Re: *Sanctuary of Peace PUDSP-19-002 – Review 2*
MVE Project No. 61087

M.V.E., Inc. has prepared the following response to comments contained in the EDARP system for Review #1. Revised submittal materials are enclosed as needed.

EL PASO COUNTY PLANNING AND COMMUNITY DEVELOPMENT DEPARTMENT

DEVELOPMENT PLAN
SITE PLAN (OVERALL)

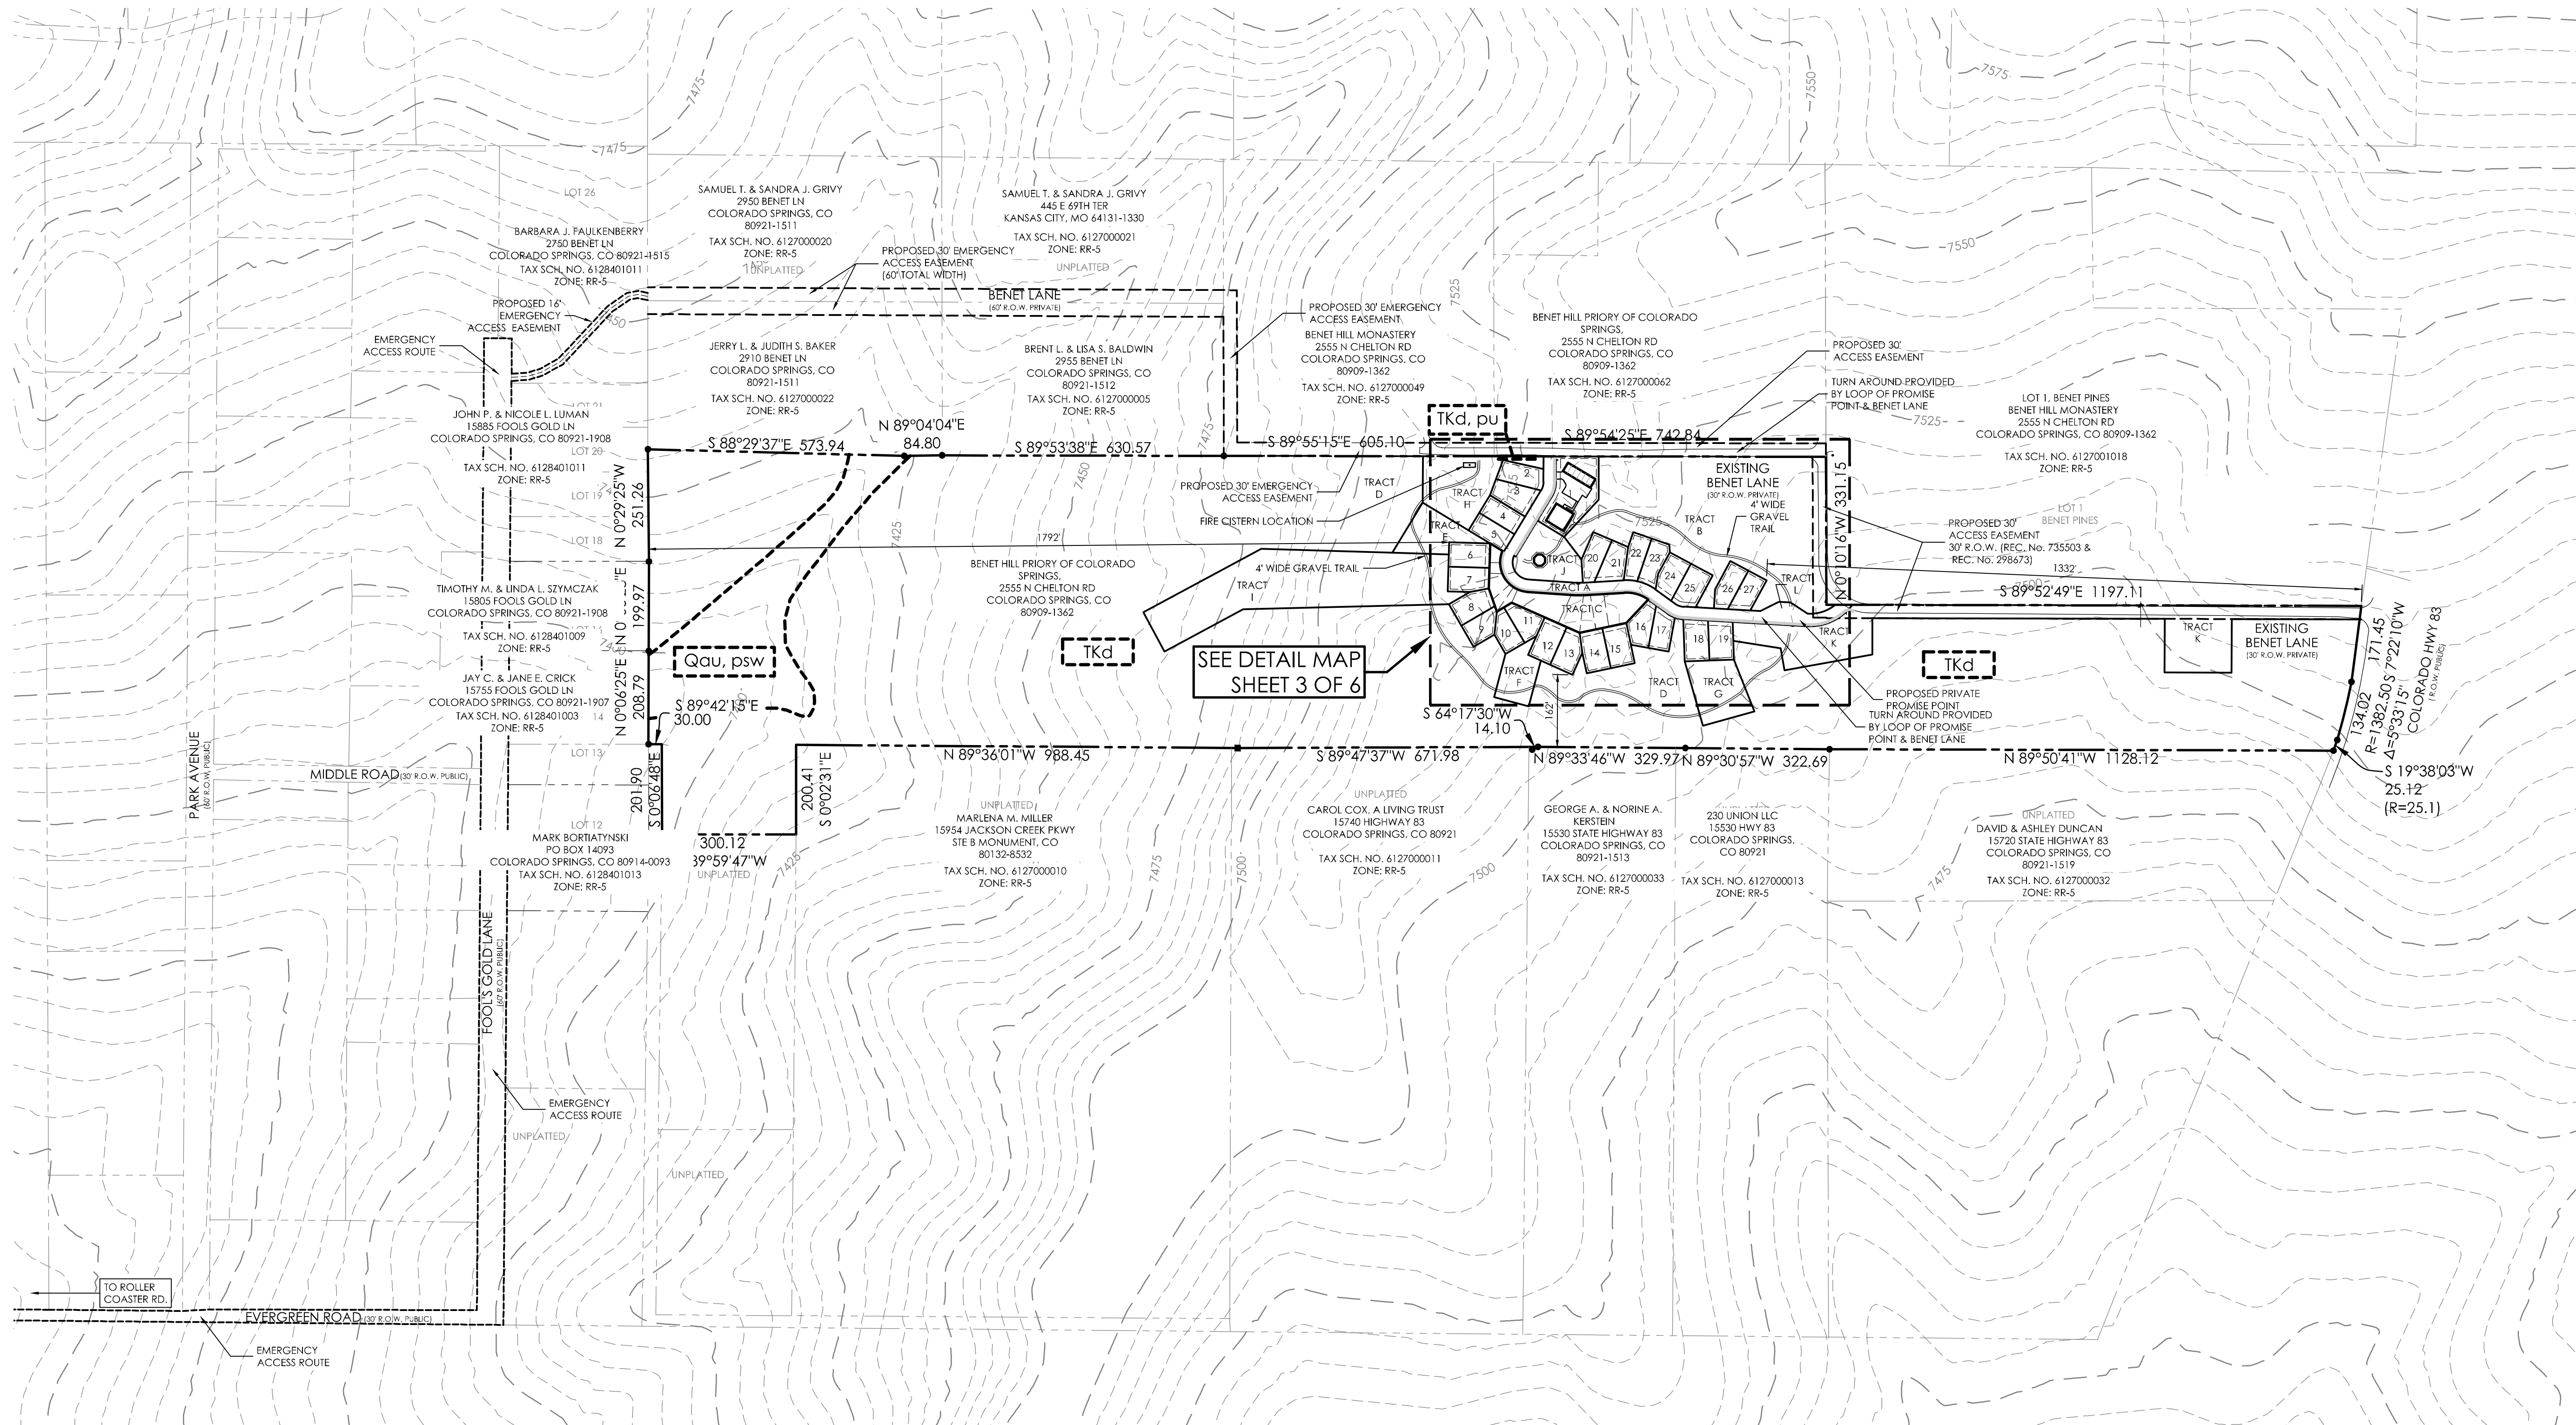
Provide the Cistern location and detail on the PUDSP Plan that the fire district is requiring. Identify in the notes who is maintain and installing the cistern Identify the cistern as an allowable use in the development standards. **The cistern location has been added to the plan and noted on sheet 1.**

DEVELOPMENT PLAN
PRELIM. GRADING & UTIL.

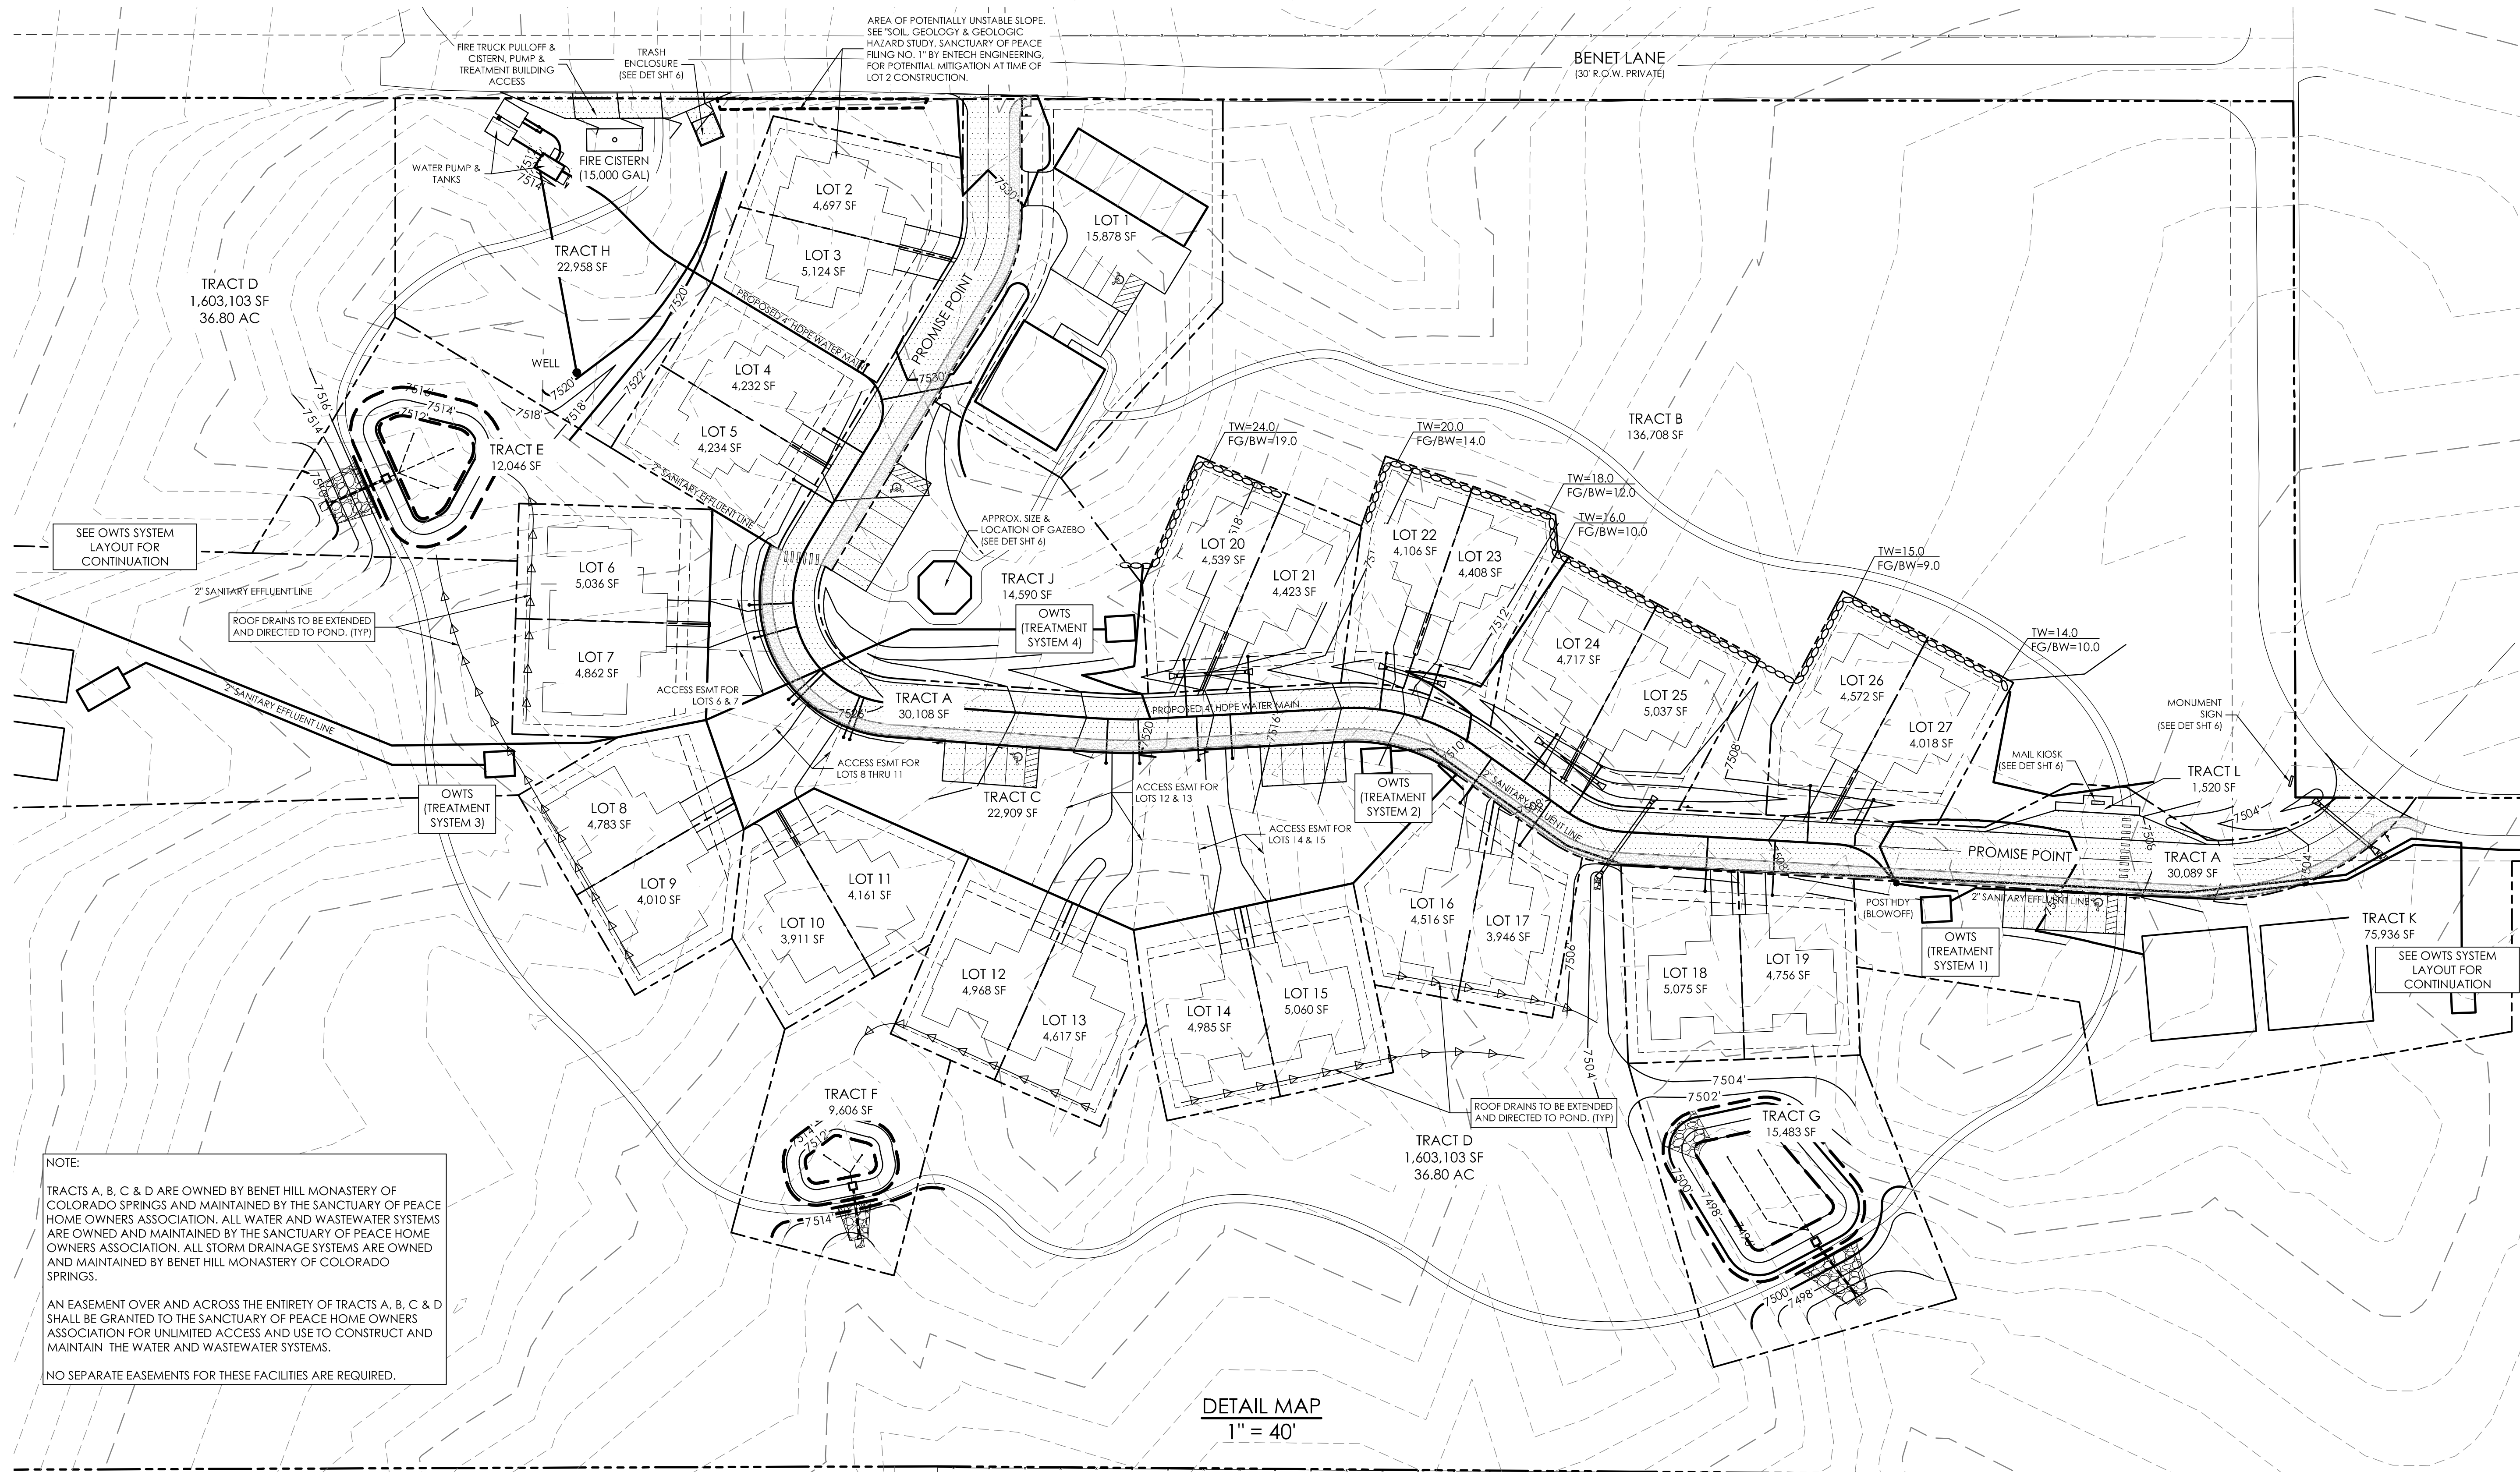
*Provide the locations of the wastewater systems; these should be in a stand alone tract or easement. How will homeowners obtain permission to address a personal home blockage? **Wastewater systems have been added to sheet 4. The applicant will provide an easement on the entirety of each tract to the HOA for ownership and maintenance of the wastewater systems. The HOA will maintain all portions of the wastewater systems which are located exterior to any unit and such is noted on sheet 1.***

Basin Land Use Characteristics

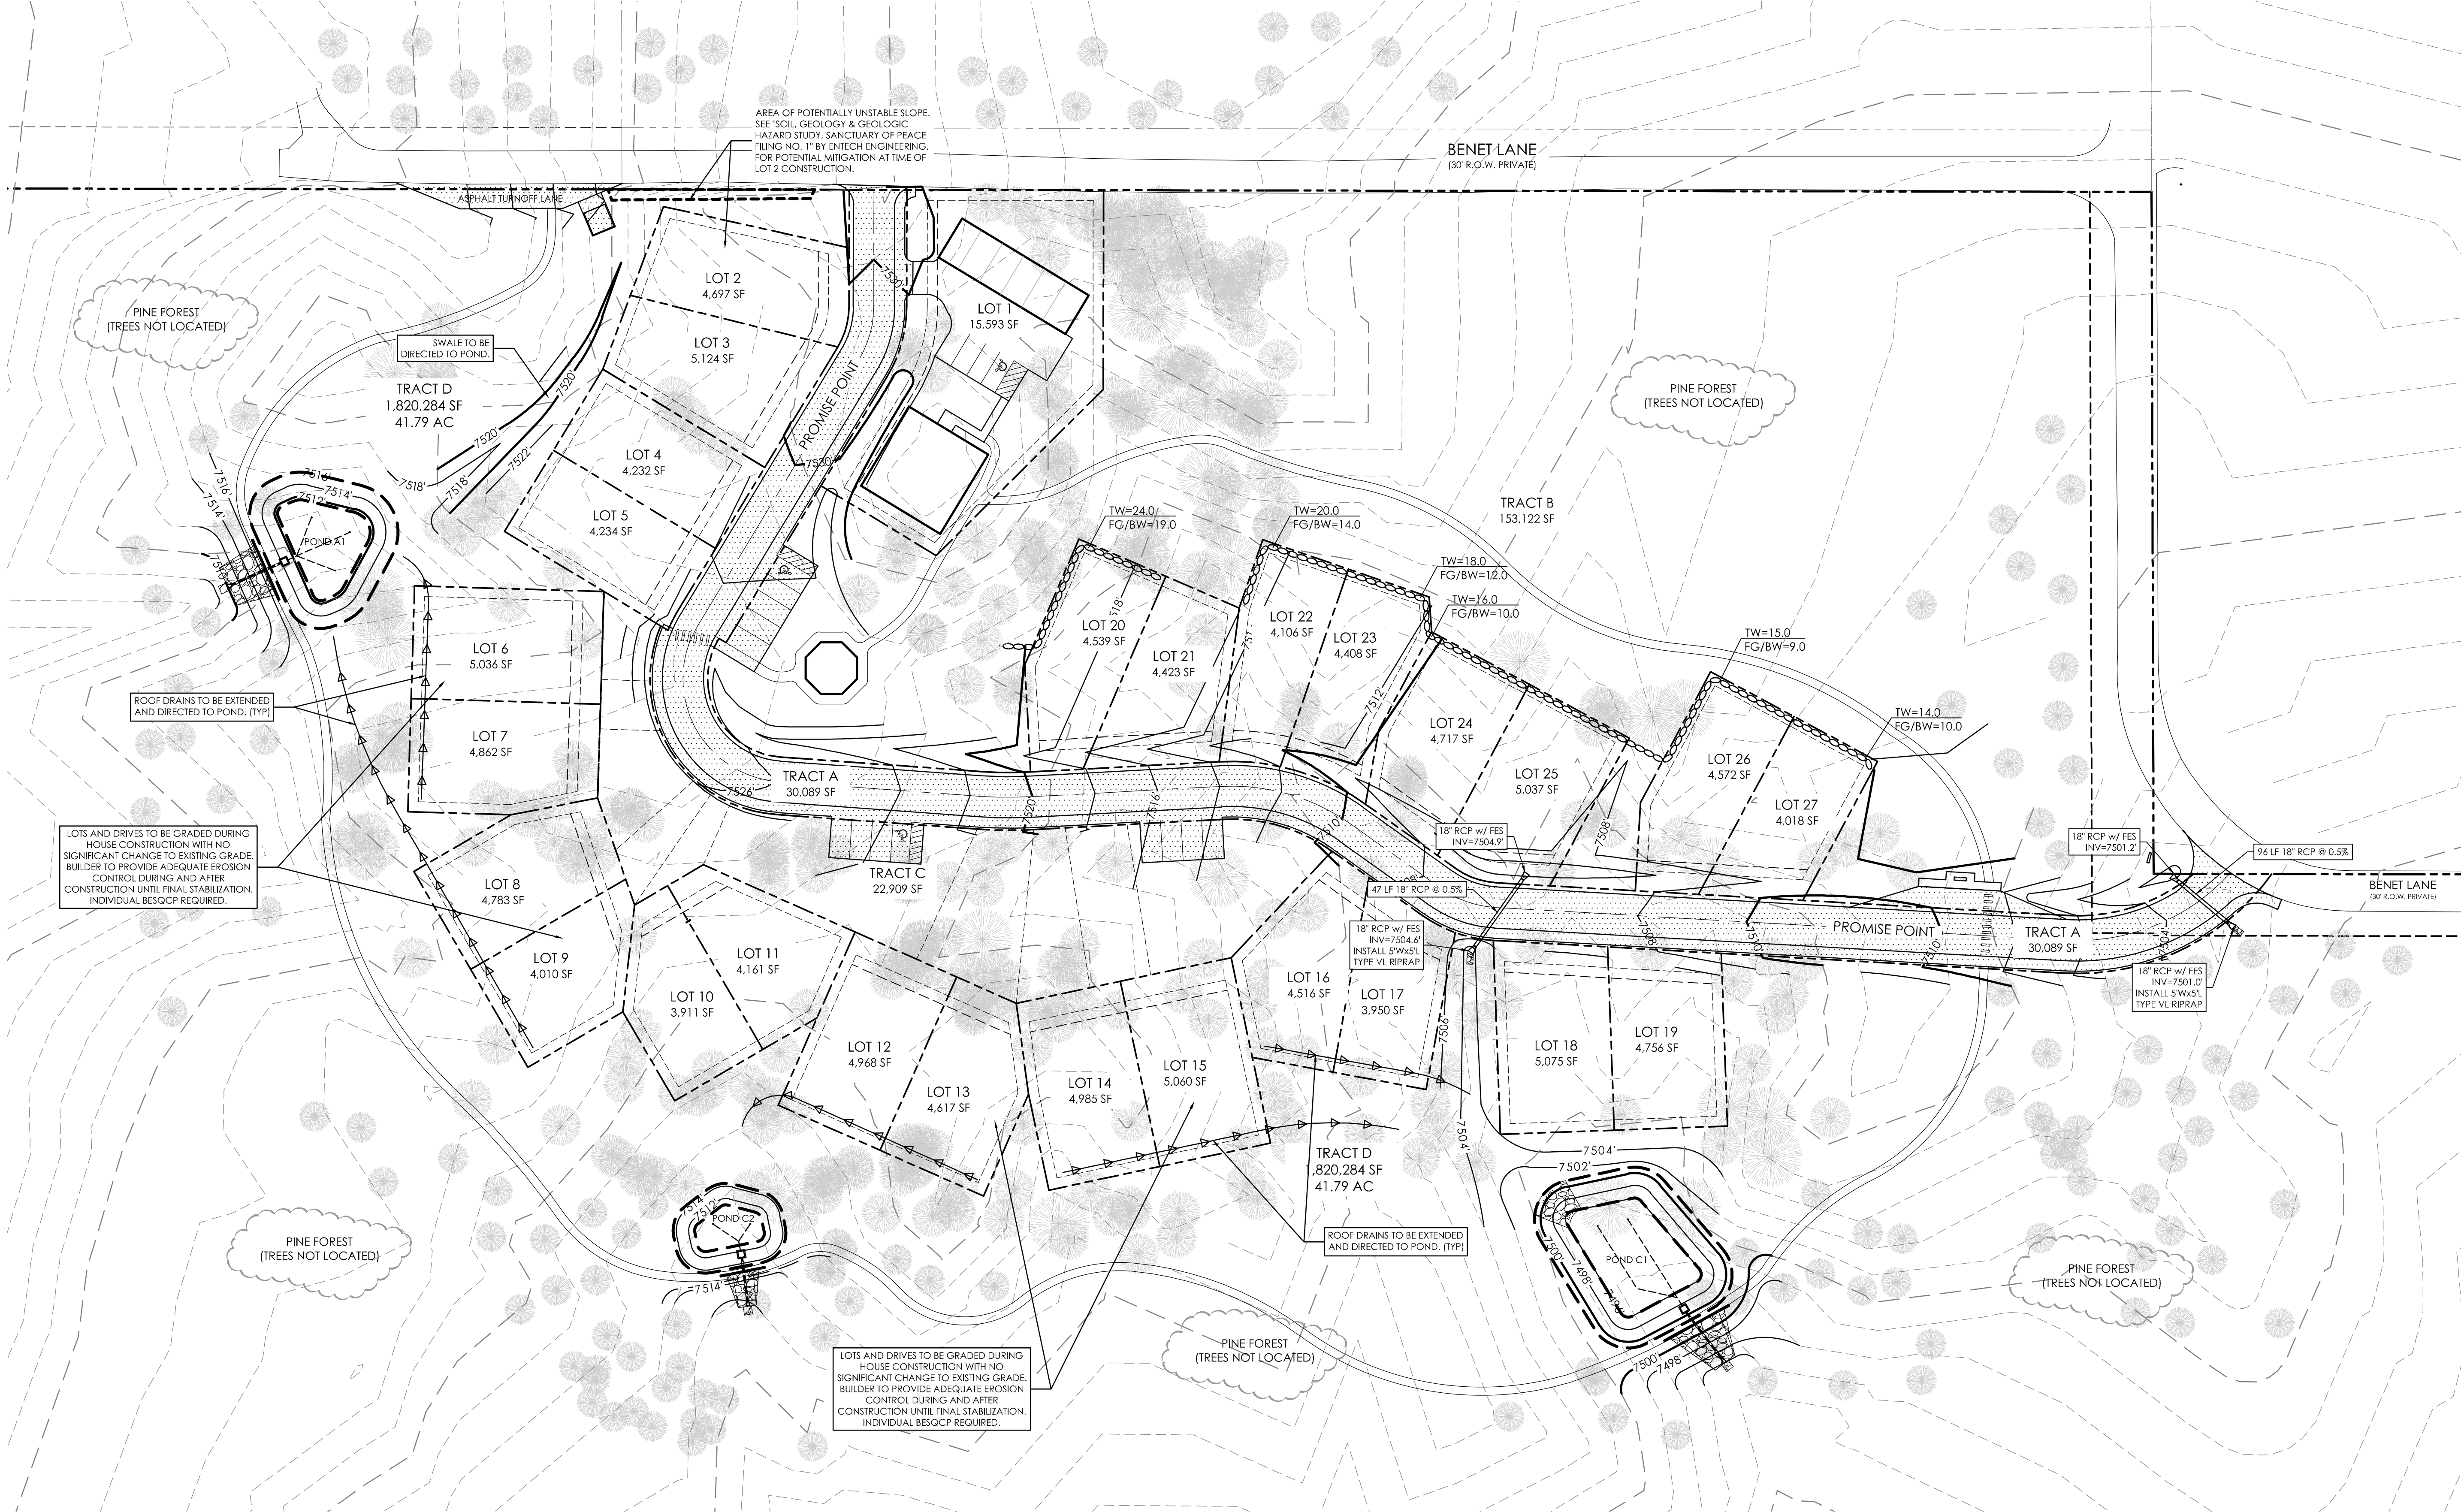
1. *Resolved. :*
2. *Resolved*
3. *See electronic redline comments*
4. *Unresolved: Call out the existing and proposed grading for the proposed housing development. Grading for the proposed housing units south of the new road still needs to be identified on the plan. **As we discussed on the phone, the area south of the roadway is not to receive grading. The homes will be constructed on the site at the existing grades with excavation for residential foundations only.***
5. *Resolved.*
